From: Chantelle Bashford <Chantelle.Bashford@arun.gov.uk>
Sent: 17 September 2021 09:31
To: Planning.Responses <Planning.Responses@arun.gov.uk>
Subject: RE: Planning Consultation on: LU/240/21/PL

Application No: LU/240/21/PL
Registered: 10th August 2021
Site Address: 12 Cornwall Road Littlehampton BN17 6EE
Grid Reference: 502760 102560
Description of Works: Change of Use from (C3) Dwelling house to 7 No. bed House in Multiple Occupation (Sui Generis)

Drawing Title
Proposed Ground and First Floor Plans

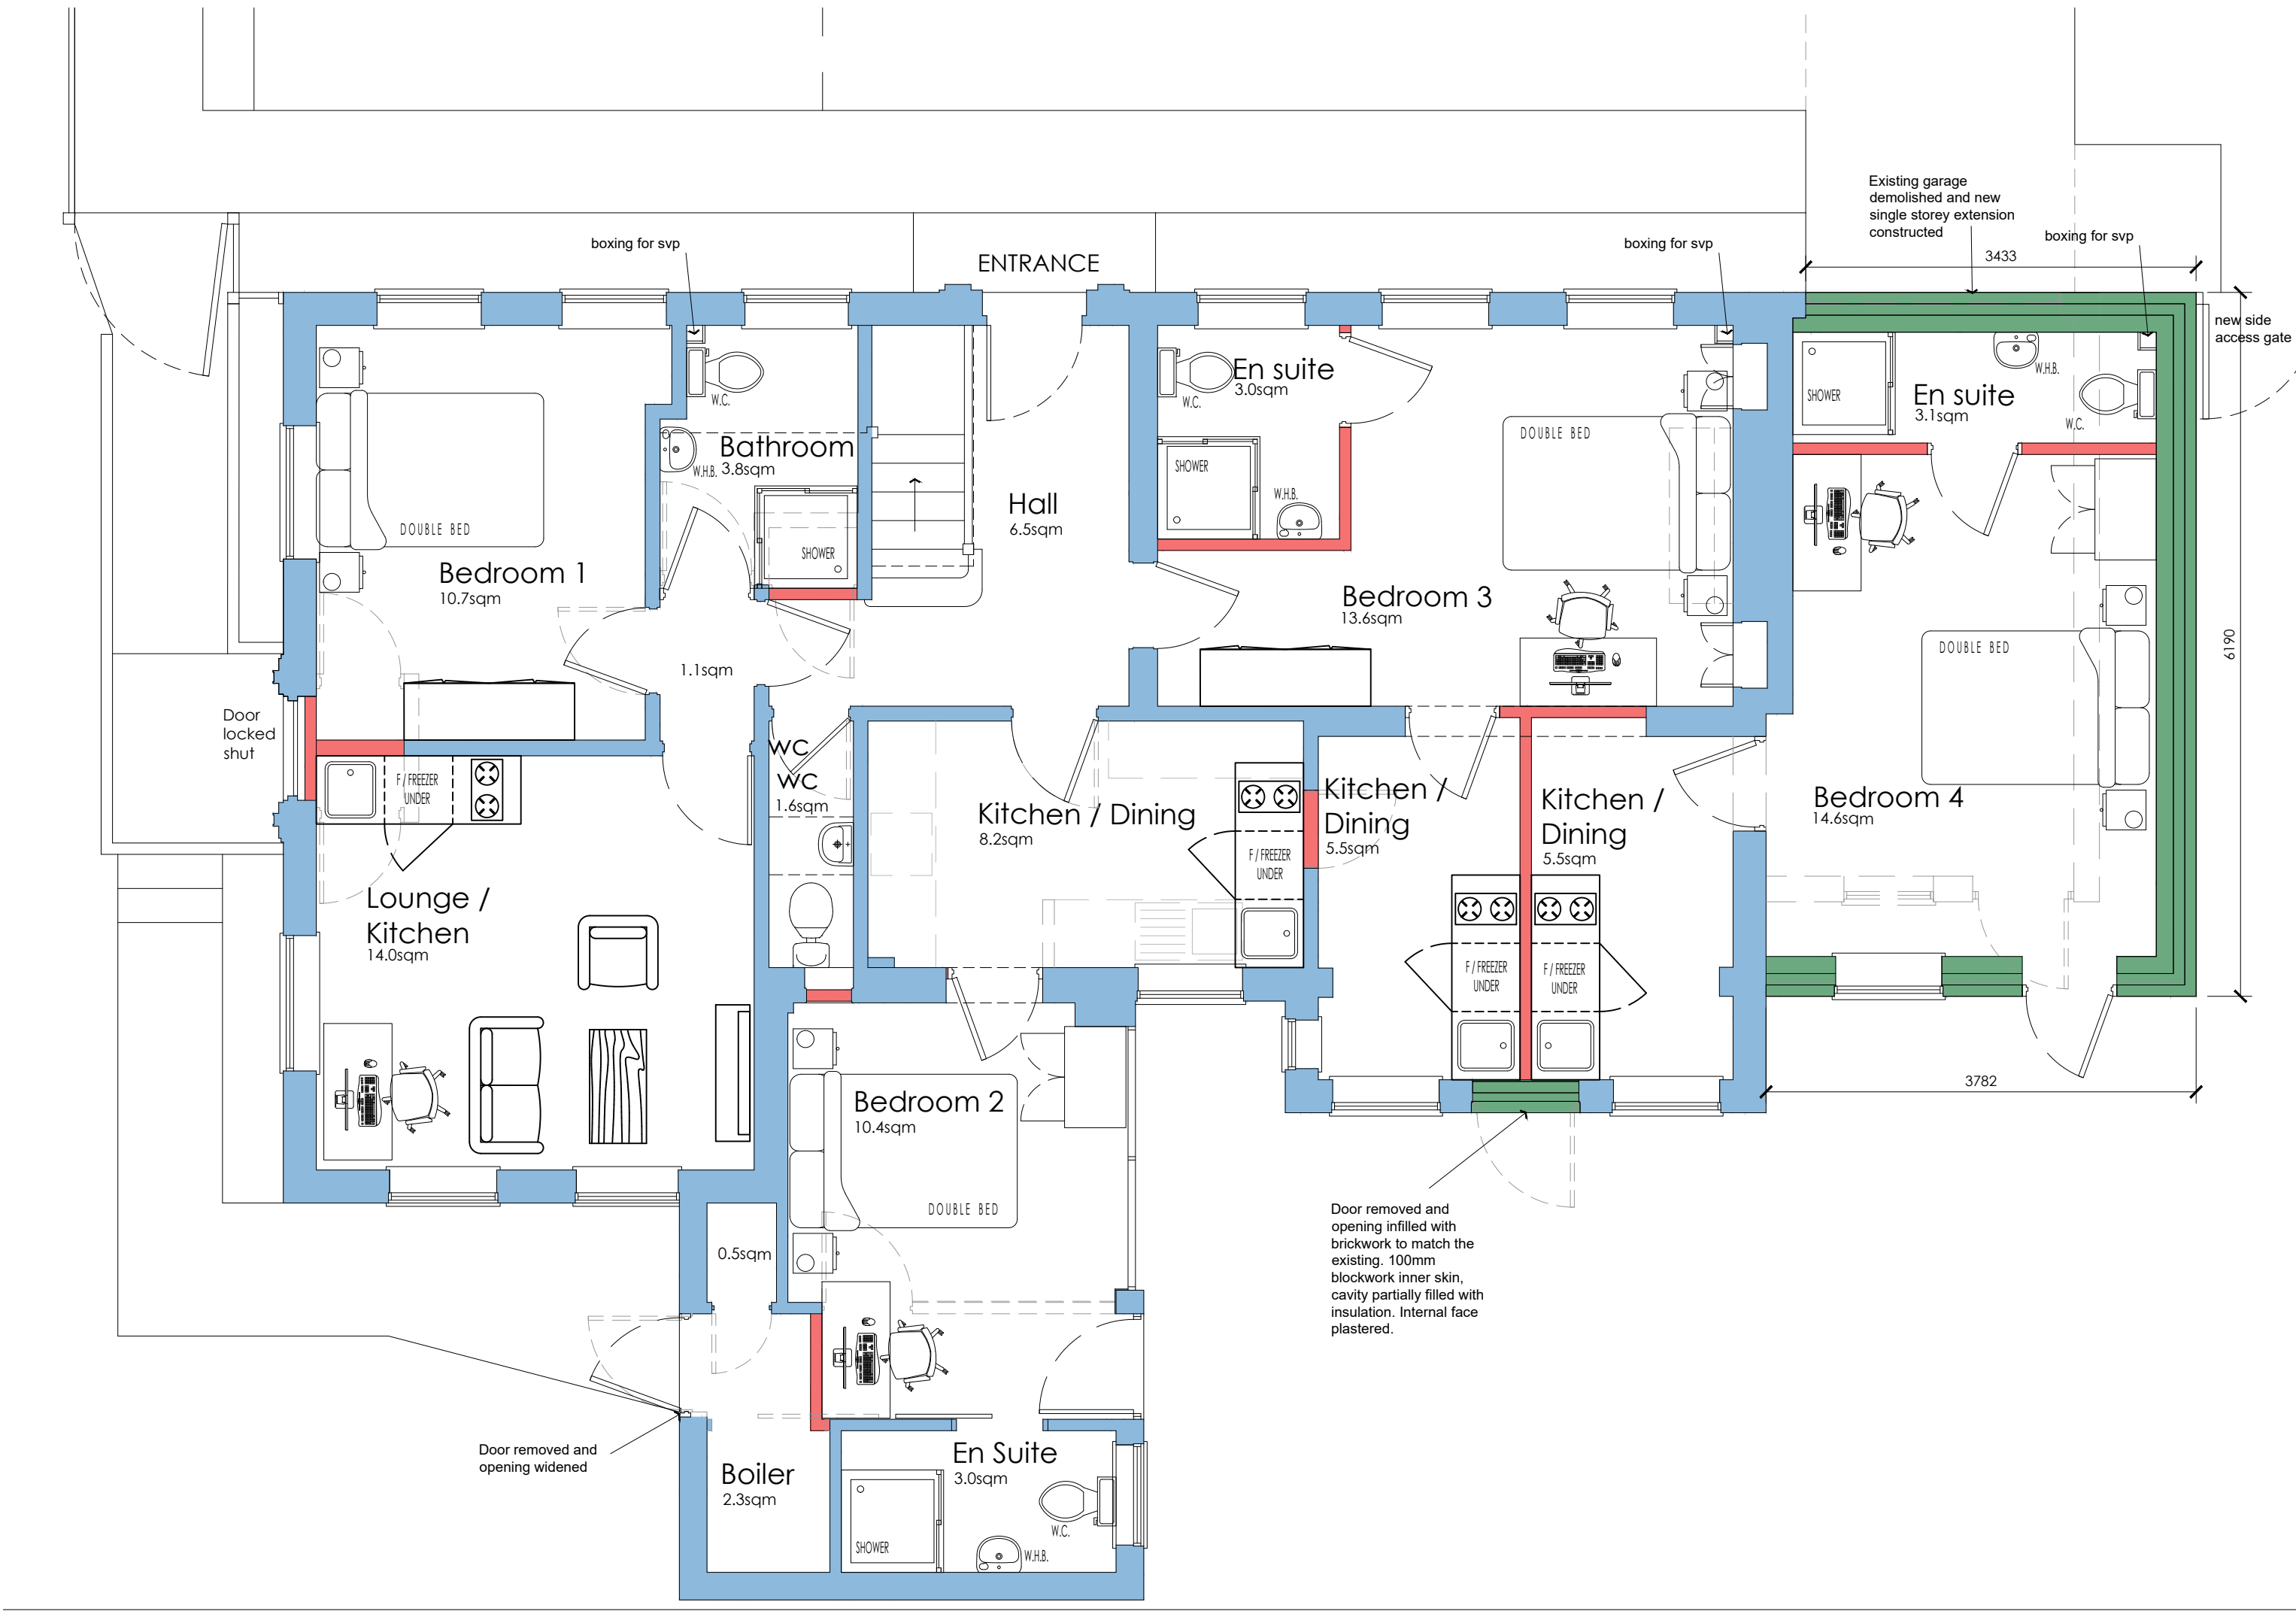
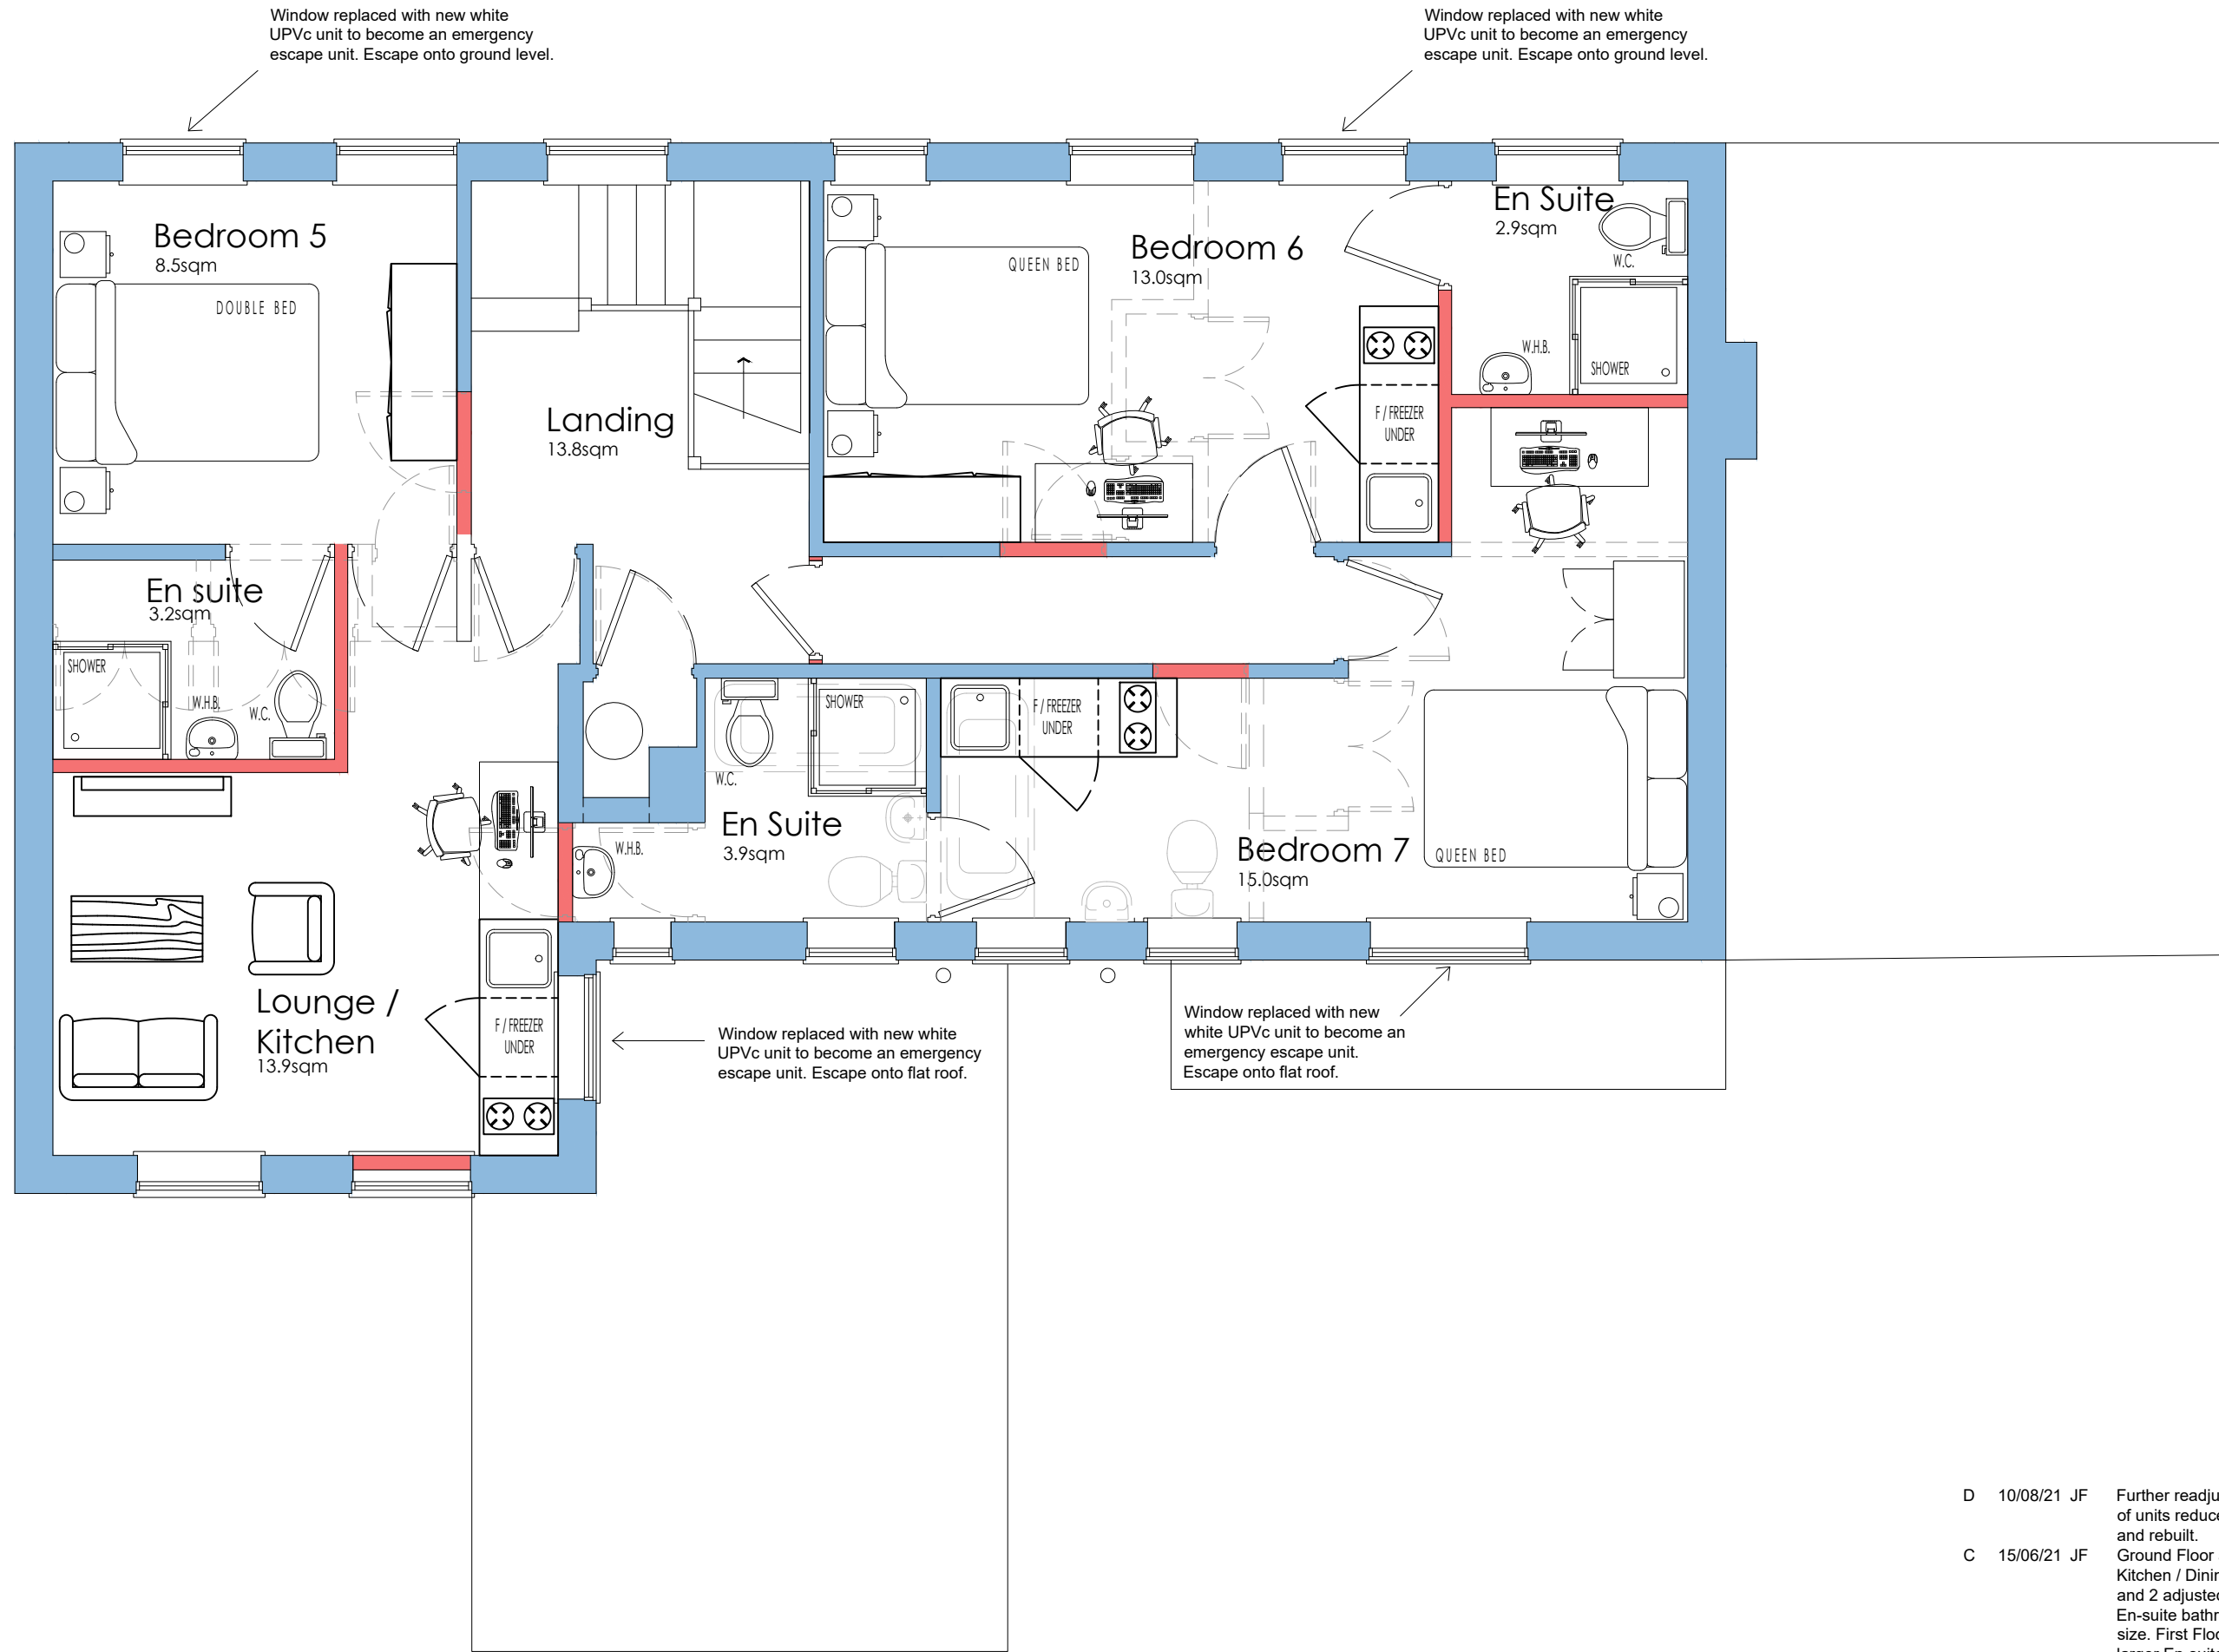
- Appropriate fire precaution facilities and equipment must be provided of such type, number and location as are considered necessary. Guidance on fire safety is contained in the LACORS guidance document – "Housing – Fire Safety, Guidance on fire safety precautions for certain types of existing housing"
- The internal escape route should provide 30 minutes fire resistance, including the provision of 30-minute fire resisting and self-closing fire doors (FD30S) to each flat entrance
- Fire blankets should be provided to all kitchen areas

- Kitchens should have adequate mechanical ventilation
- Mechanical extraction should be provided to all bathrooms/shower rooms/en suites
